Rezoning Transportation Analysis

Petition Number: 2019-179

From: Felix Obregon, PE
fobregon@charlottenc.gov
704-432-5729

Date	Description
01-15-2020	First Review
02-17-2020	Second Review
04-23-2020	Third Review

# RZ-1.0

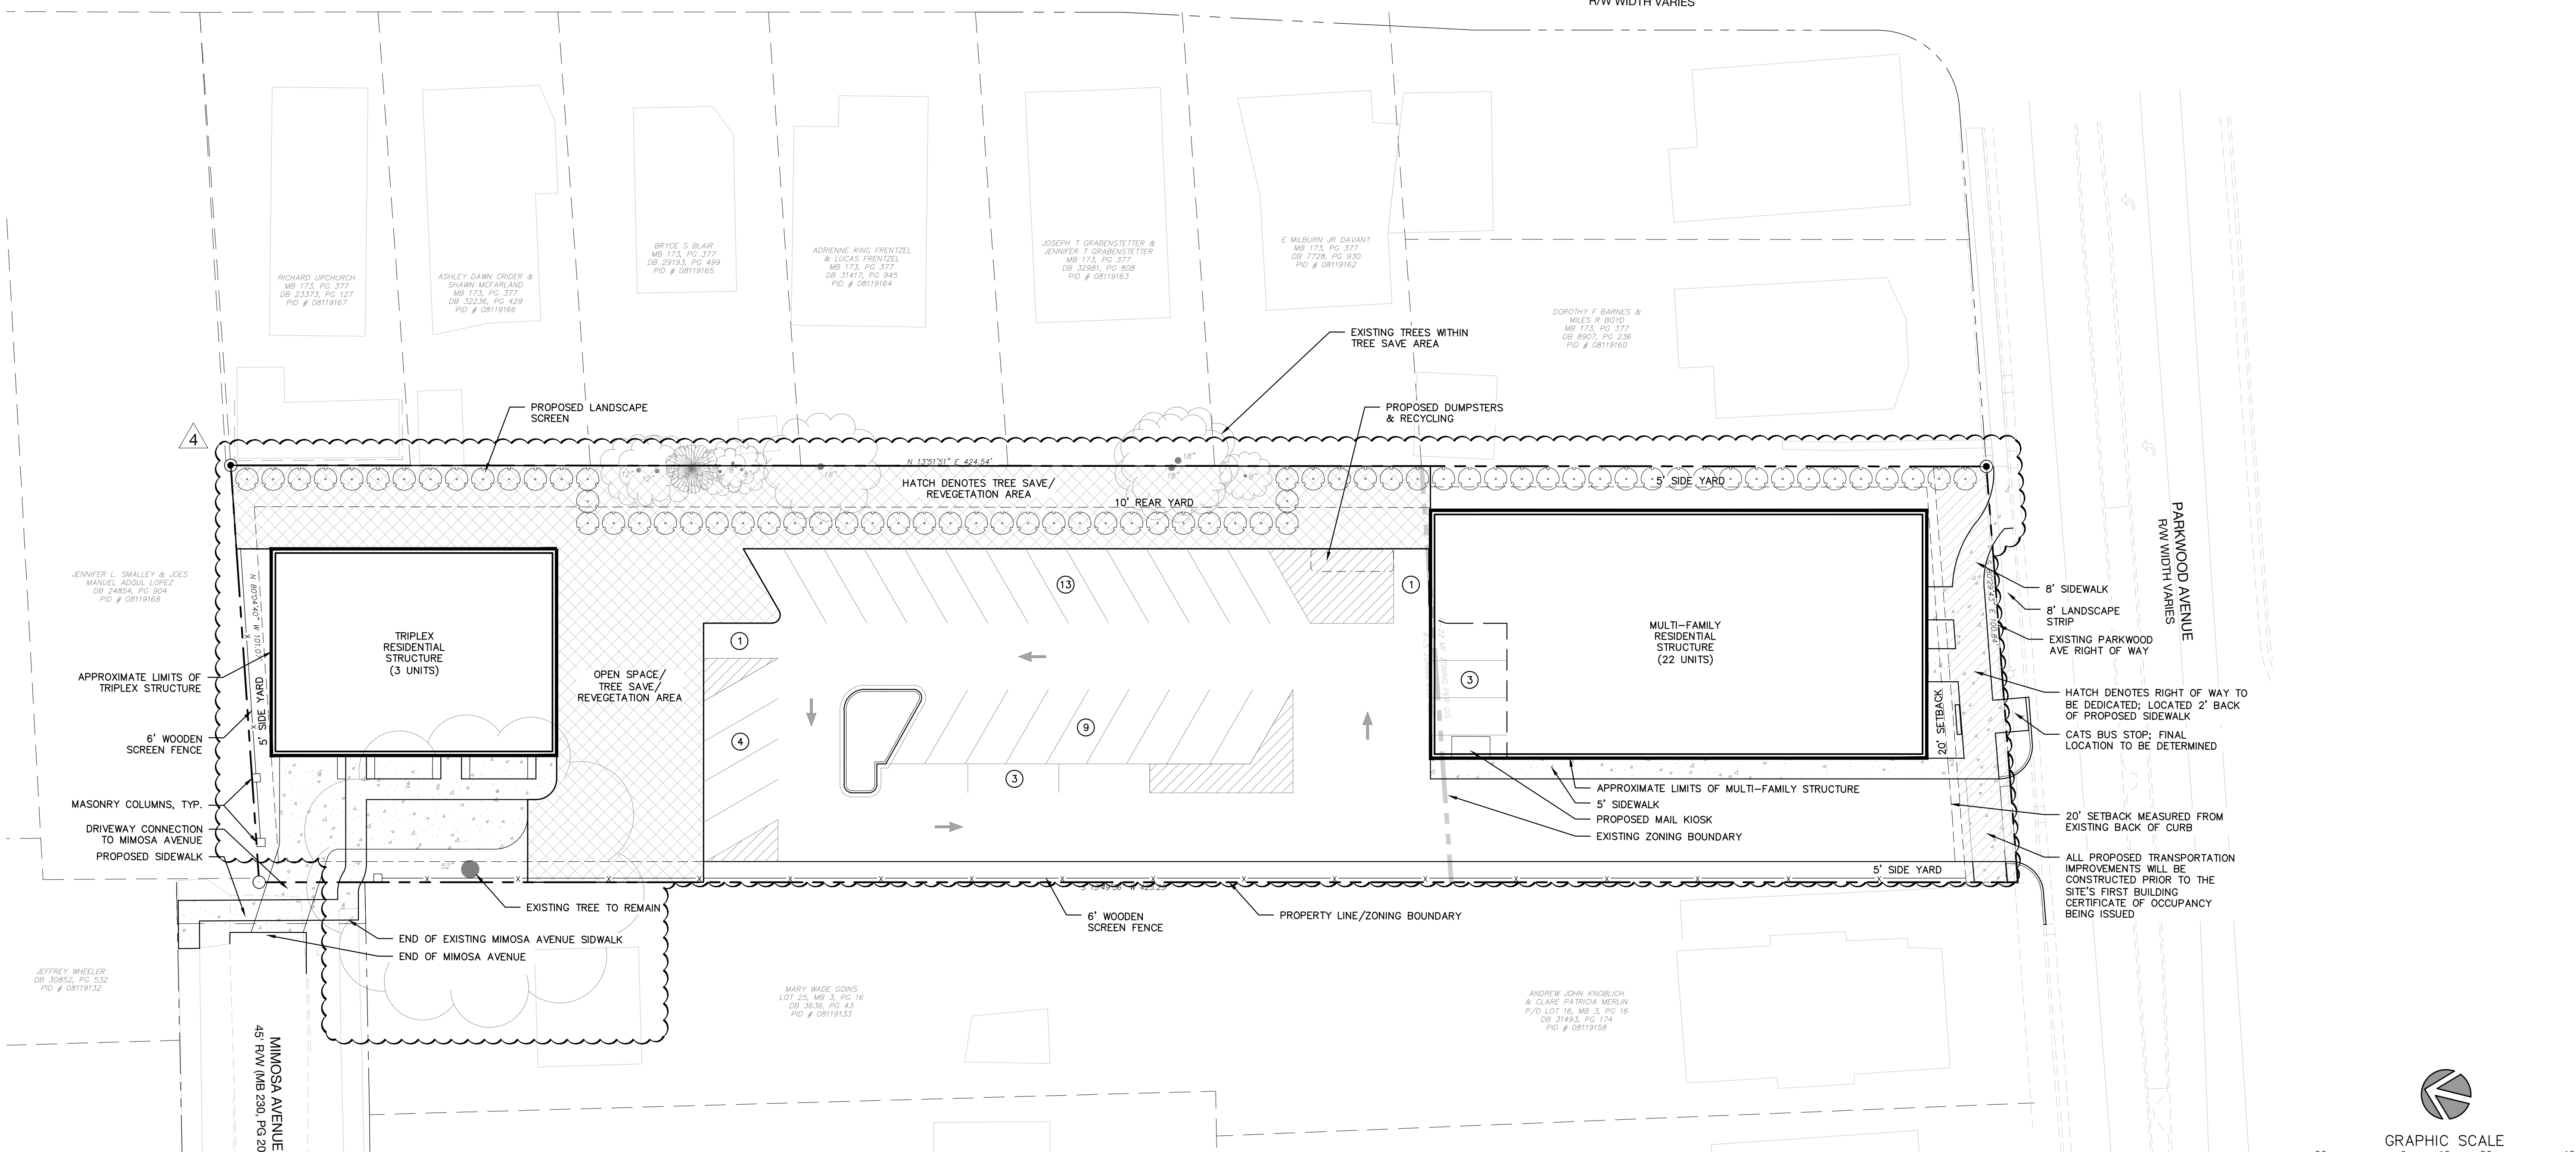
4. The petitioner should revise the site plan and conditional note(s) to construct private drive to a public USDG standard. This a requirement of the Subdivision ordinance. If the proposed access meets the required ordinance, please provide the documentation stating it meets the ordinance.

9. **New Comment based on site plan 04/14/2020:** Petitioner should revise the driveway to Mimosa Avenue to meet Charlotte Land Development Standards Manual for two-way circulation since it is a shared driveway.
